WEST SUSSEX COUNTY COUNCIL CONSULTATION

TO:	Arun District Council FAO: Zac Denton
FROM:	WSCC - Highways Authority
DATE:	13 August 2020
LOCATION:	Little Thatch 93 Middleton Road Bognor Regis PO22 6DW
SUBJECT:	M/47/20/HH Construct a new site access from Middleton Road.
DATE OF SITE VISIT:	n/a
RECOMMENDATION:	Advice
S106 CONTRIBUTION TOTAL:	n/a

Nº 93 MIDDLETON ROAD
PROPOSED NEW VEHICULAR ACCESS
ENTRANCE DESIGN DETAILS

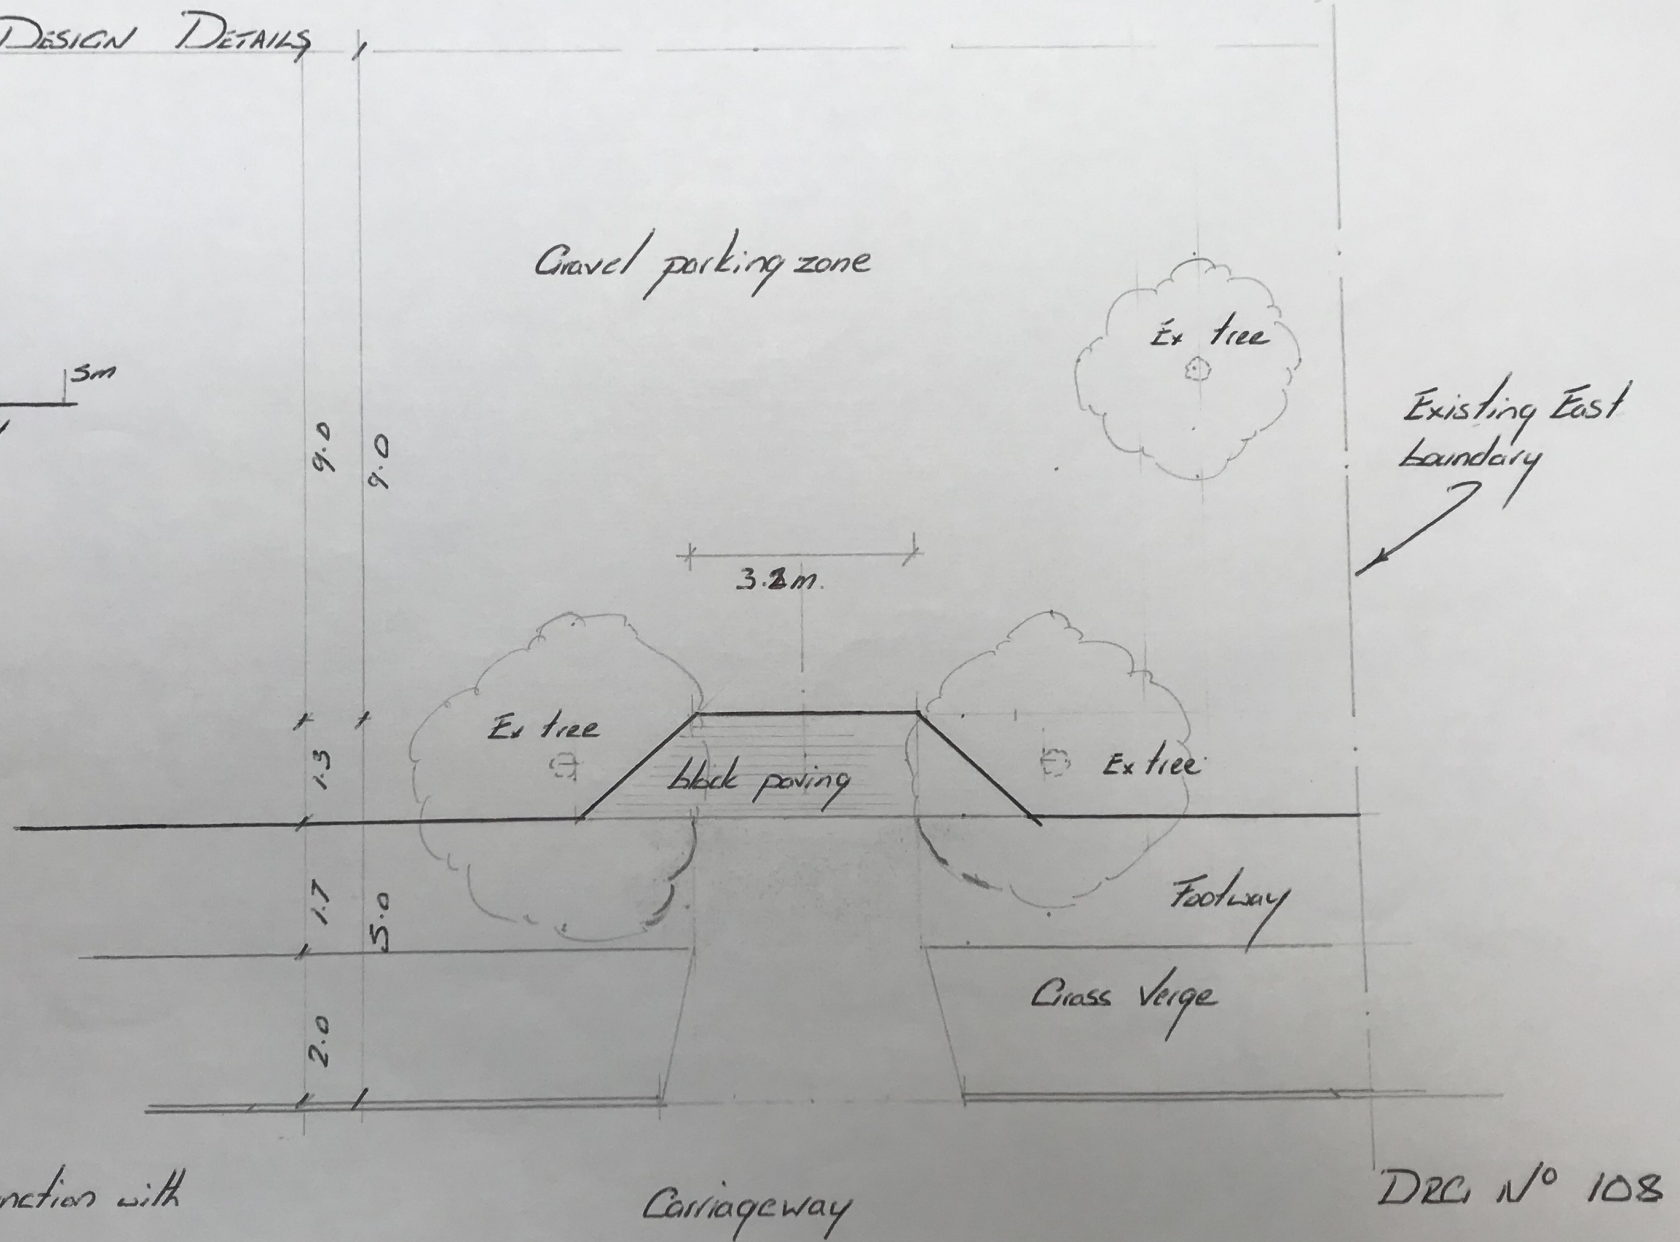
The applicant proposes to relocate the new access to the centre of the property line. The LHA understands the benefits of increasing visibility in doing so. The proposed VCO width is 3.9 metres. The applicant is advised to increase this to a more desirable width of 4.3 metres, details of which can be secured via a suitably worded condition.

DRAWING 105^A
PROPOSED AND EXISTING
STREET ELEVATION
1:250
APRIL 2018
Revision: A new entrance added.

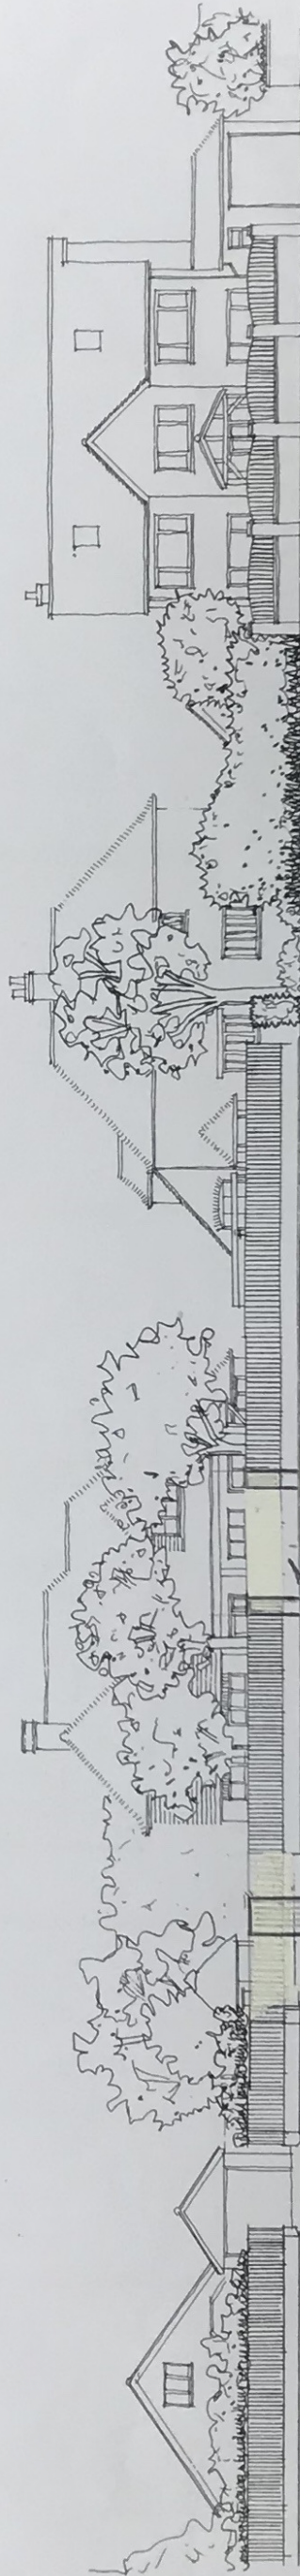
The applicant has not provided details for closing up the existing access. The LHA wishes to see these details either during this planning application or details to be secured via a suitably worded condition.
